Please upload the below to the above application. Drainage Engineers comments.

Engineers Comments Regarding Surface Water Drainage

Application No: BN/81/20/DOC

Description of Works: Approval of details reserved by condition imposed under ref BN/121/19/PL relating to Condition Nos 3 - surface water drainage, 4 - Construction Management Plan, 5 - materials & finishes, 6 - hard & soft landscaping, 7 - drainage scheme, 8 - storage of waste and 13 - renewable energy.

Revision:			
address Swallowfield, Eastergate Lane Eastergate, PO20 3SJ			
project Proposed construction of detached chalet bungalow			
title Proposed Surface Drainage			
scale 1:500 @A4	date May 2020	dwg no 2019.257DRA	revision

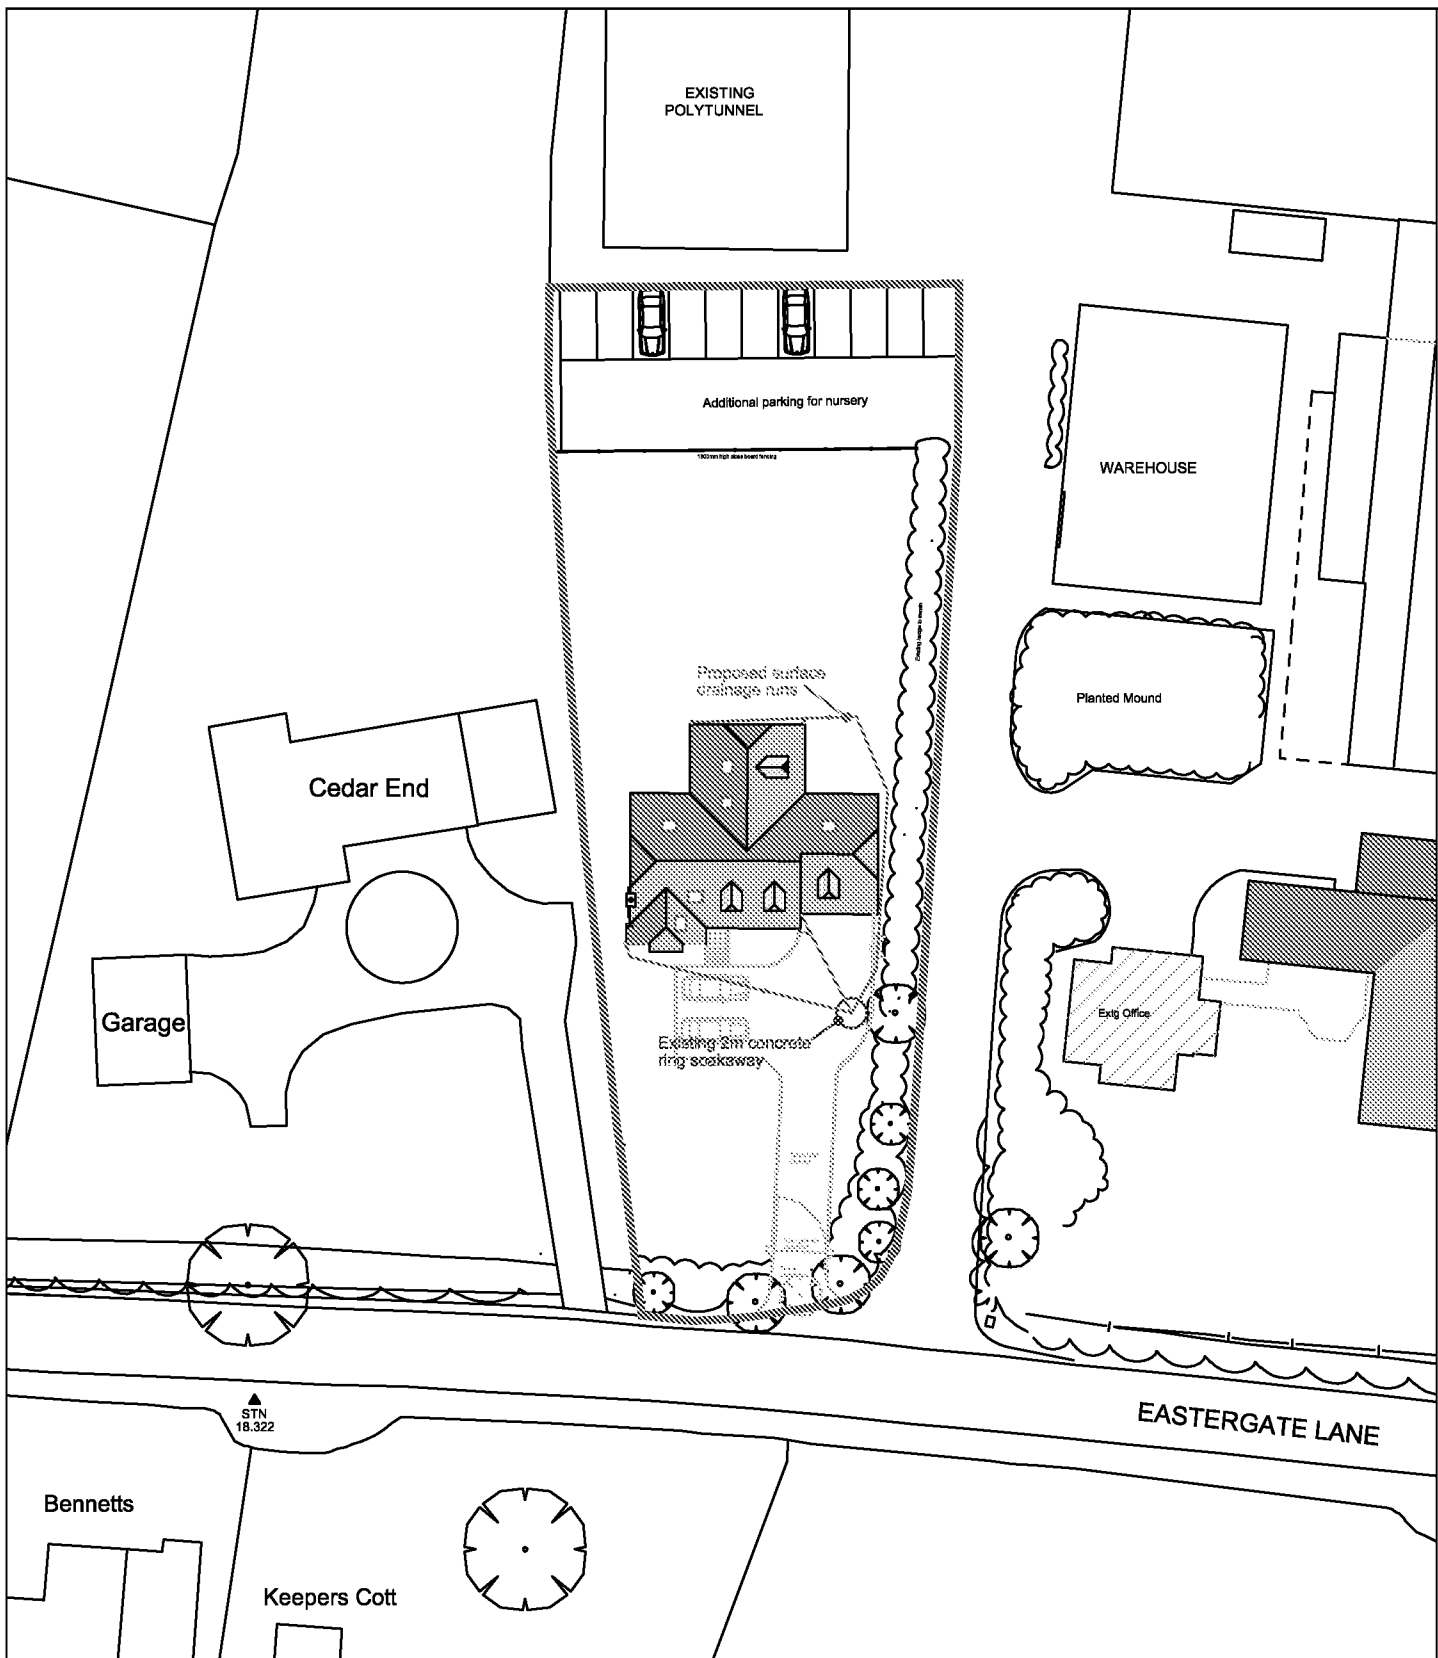
The information supplied is insufficient to recommend discharge of condition 3 and 7 on application BN/121/19/PL. Whilst the principle of utilising the existing soakaway may be feasible, calculations will need to be provided to show that it meets our requirements, and a detailed drainage layout and construction details will also be required. These calculations will rely upon winter infiltration testing (and groundwater monitoring) as per condition 3.

We provide a [Surface Water Drainage Checklist](#) which applicants are guided to in an informative on their decision notice, this makes clear the level of detail required in terms of testing, calculations, the drainage layout and the construction detail drawings. Given that we are currently months away from the winter period, unless the applicant is able to provide winter results from a previous year, I would recommend that the application is refused and a new submission is made in early 2021.

Revision:			
address Swallowfield, Eastergate Lane Eastergate, PO20 3SJ			
project Proposed construction of detached chalet bungalow			
title Proposed Infiltration Results			
scale 1:500 @A4	date Aug 2020	dwg no. 2019.257INF	revision

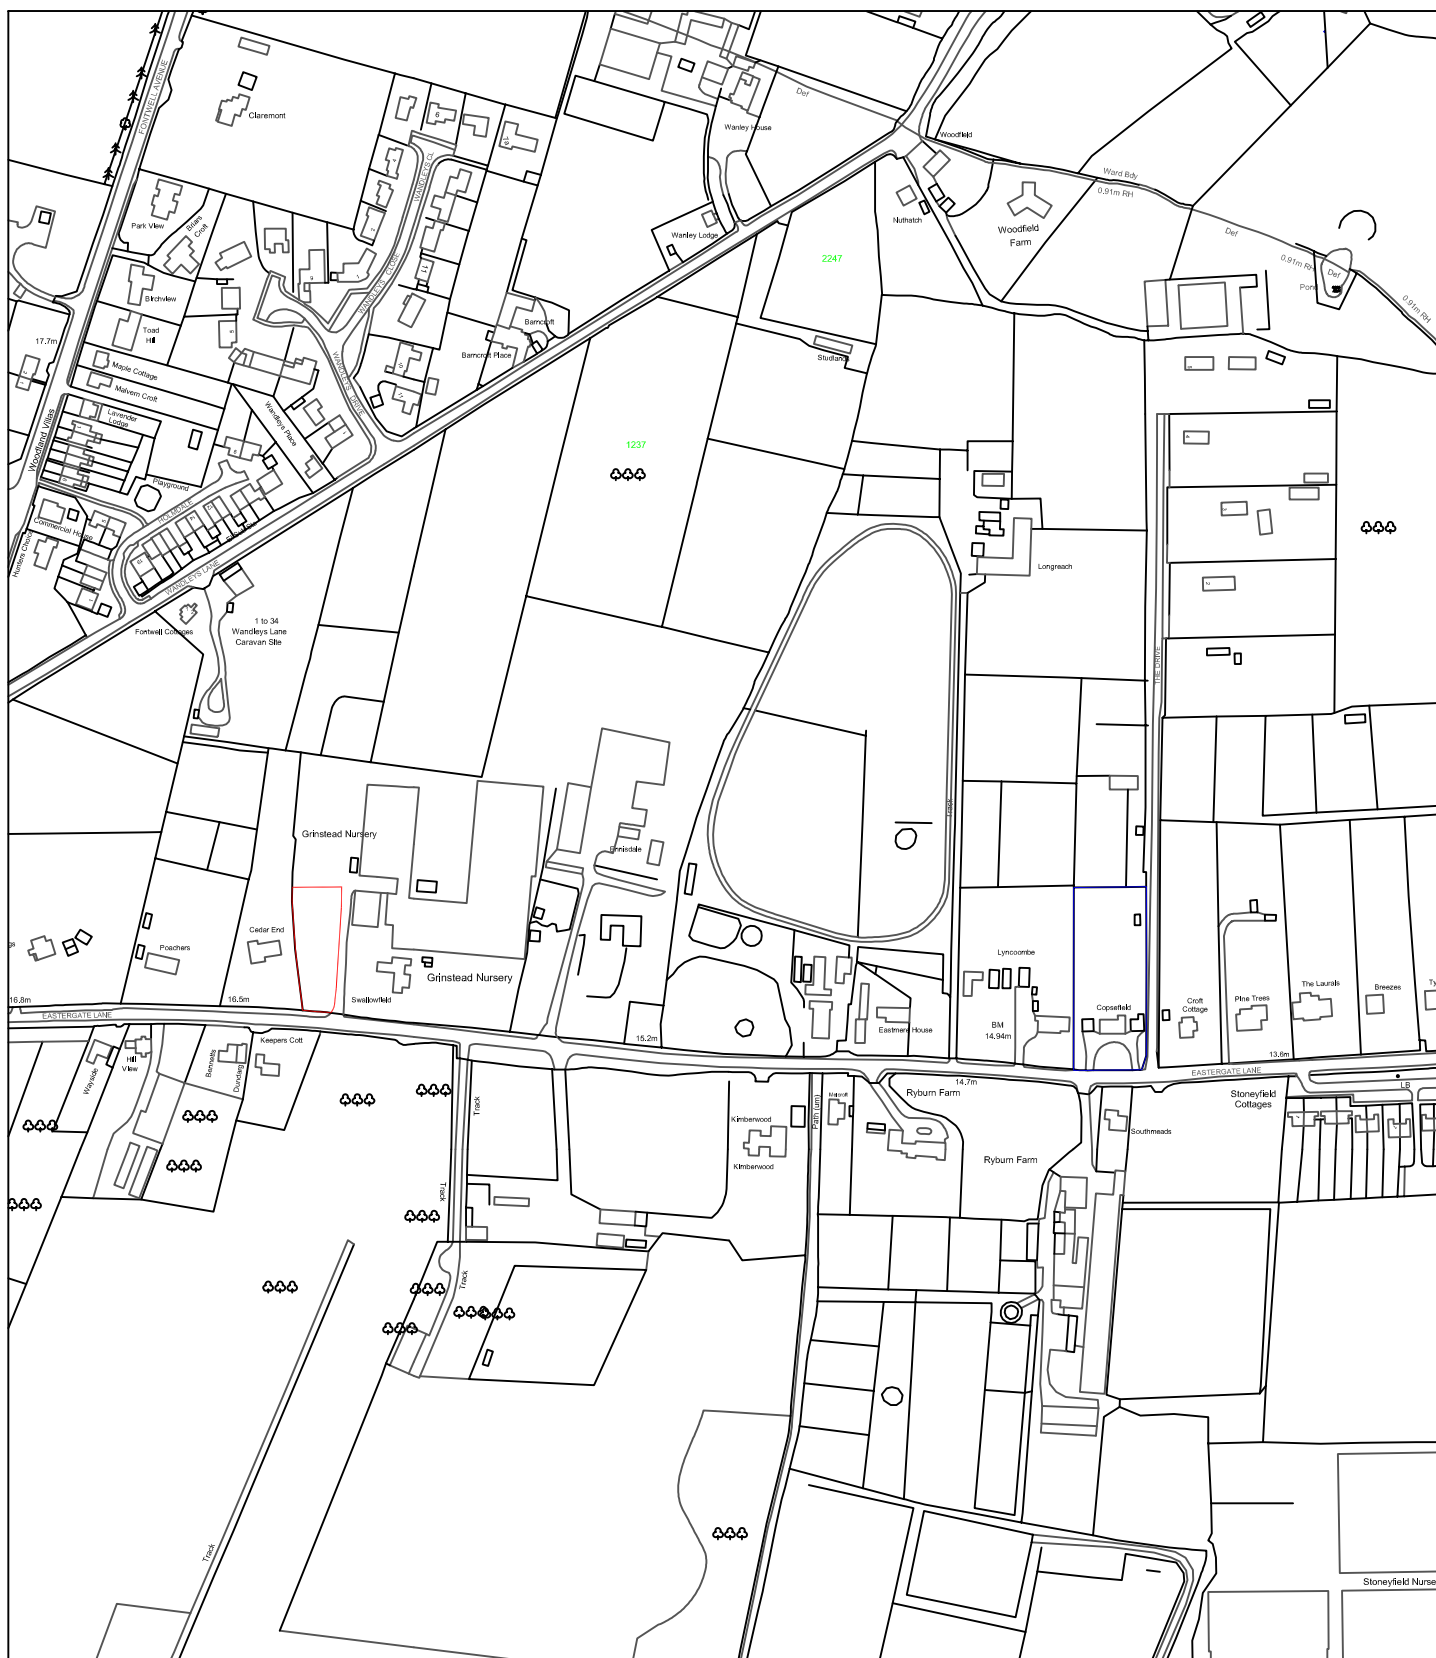
Sorry I had a particularly busy day yesterday before I went on leave, I woke and remembered about this so have logged on to give you a reply, but will be on leave from now and will not be switching on phone/e-mails. The results that Matt is proposing that they use, are slightly beyond what I am comfortable with. That said, I would expect infiltration to be good in this area and this is a single property being sited where there was an existing impermeable area and soakaway.

I would suggest that a compromise would be to use this data but I would like a safety factor of at least 3 applied in the calculations. I am happy to provide a second consultation for this application once a design has been provided. The applicant will have to meet all criteria as shown in the drainage checklist. I would also be keen to see the difference (if any) in topographic levels between this site and Copefield so that the groundwater level can be adjusted if needs be.

Further to our conversation earlier today please find enclosed a drawing showing the location of our proposed property (outlined in red) and the new property where we were proposing to use the infiltration results from (outlined in blue), it measures 387m from our site.

The area is well known to have excellent filtration and I hope you can agree that this is near enough for us to assume a filtration rate for our site.
